D.R. HORTON - GRANDVIEW RESERVE SANITARY SEWER LIFT STATION DESIGN & PERMITTING SERVICES

90% CONSTRUCTION DOCUMENTS

PCD # PPR-24-21

CIVIL
SITE PLAN

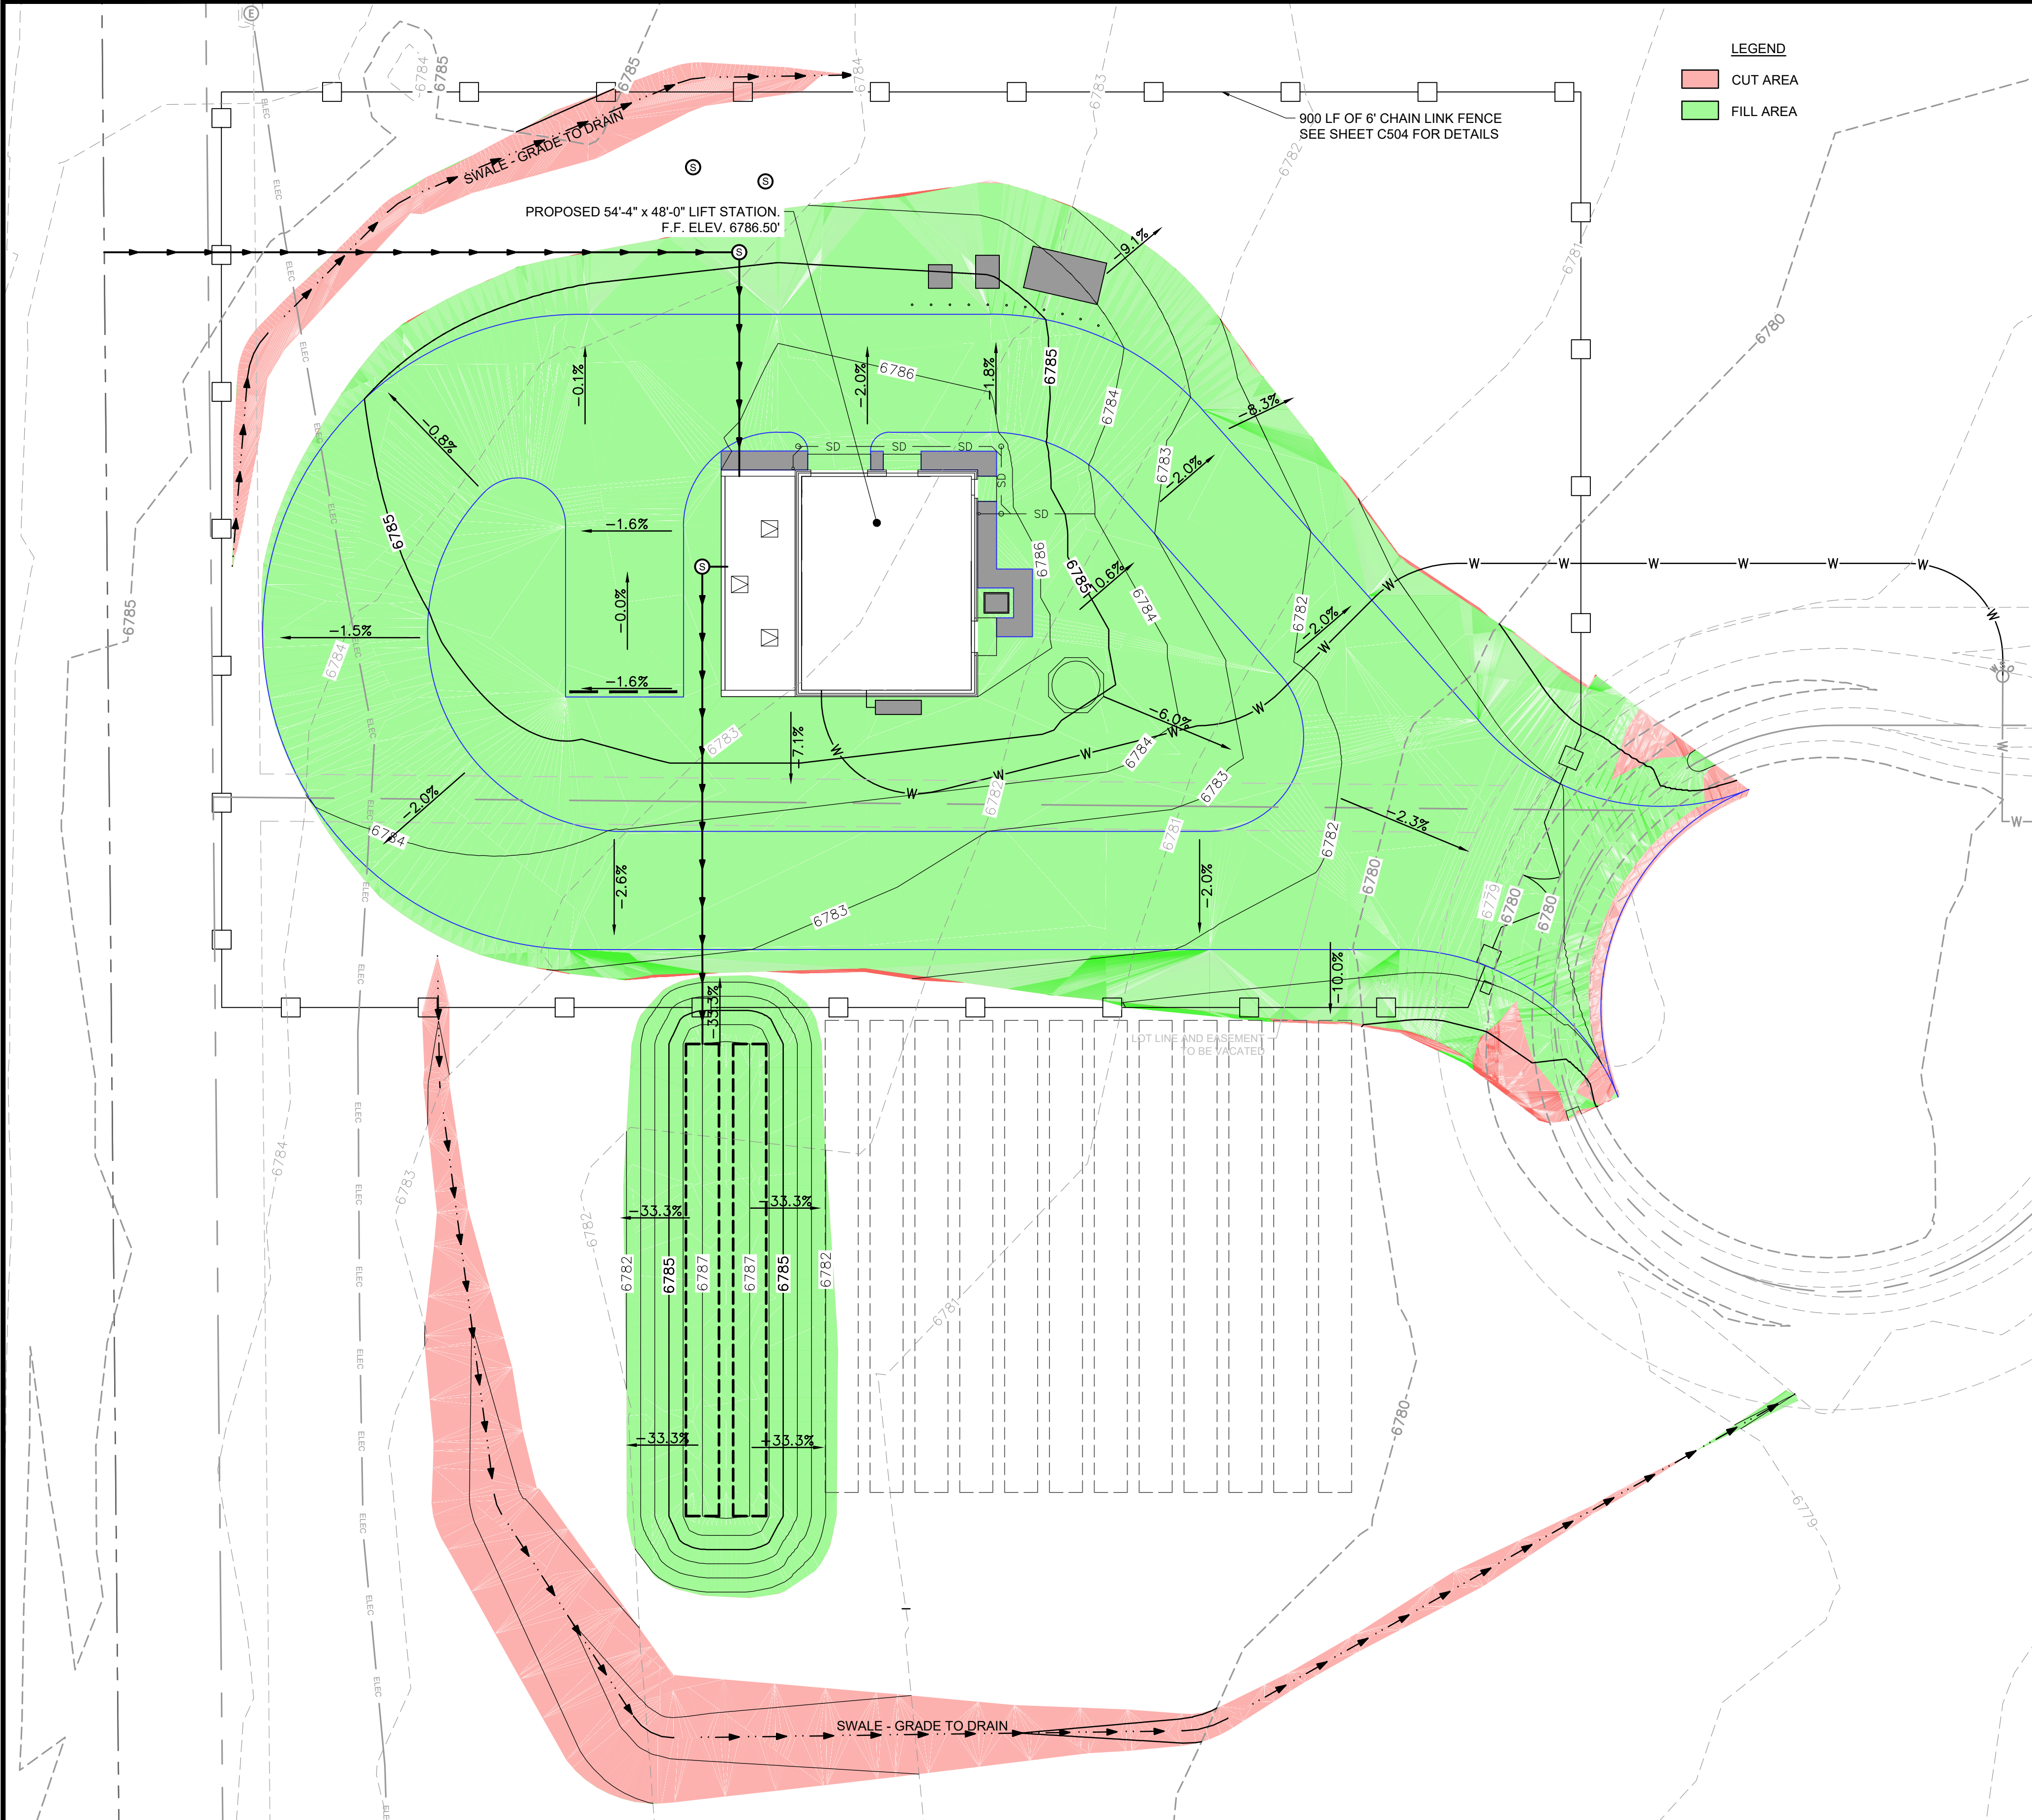
Please include:

- Setback distances of all structures to all property lines
- Traffic circulation into and off the property
- Location and dimensions of all existing and proposed signs, if none, please specify
- Footprint of all existing buildings
- Dimensions of property lines
- Location of easements
- Layout of parking and dimensions of parking spaces
- Location of all ADA spaces
- Location of all no-build areas, floodplain, drainageways and facilities
- Location of all garbage receptacles with a graphical depiction of the screening mechanism
- Location of all existing and proposed utility lines and associated infrastructure
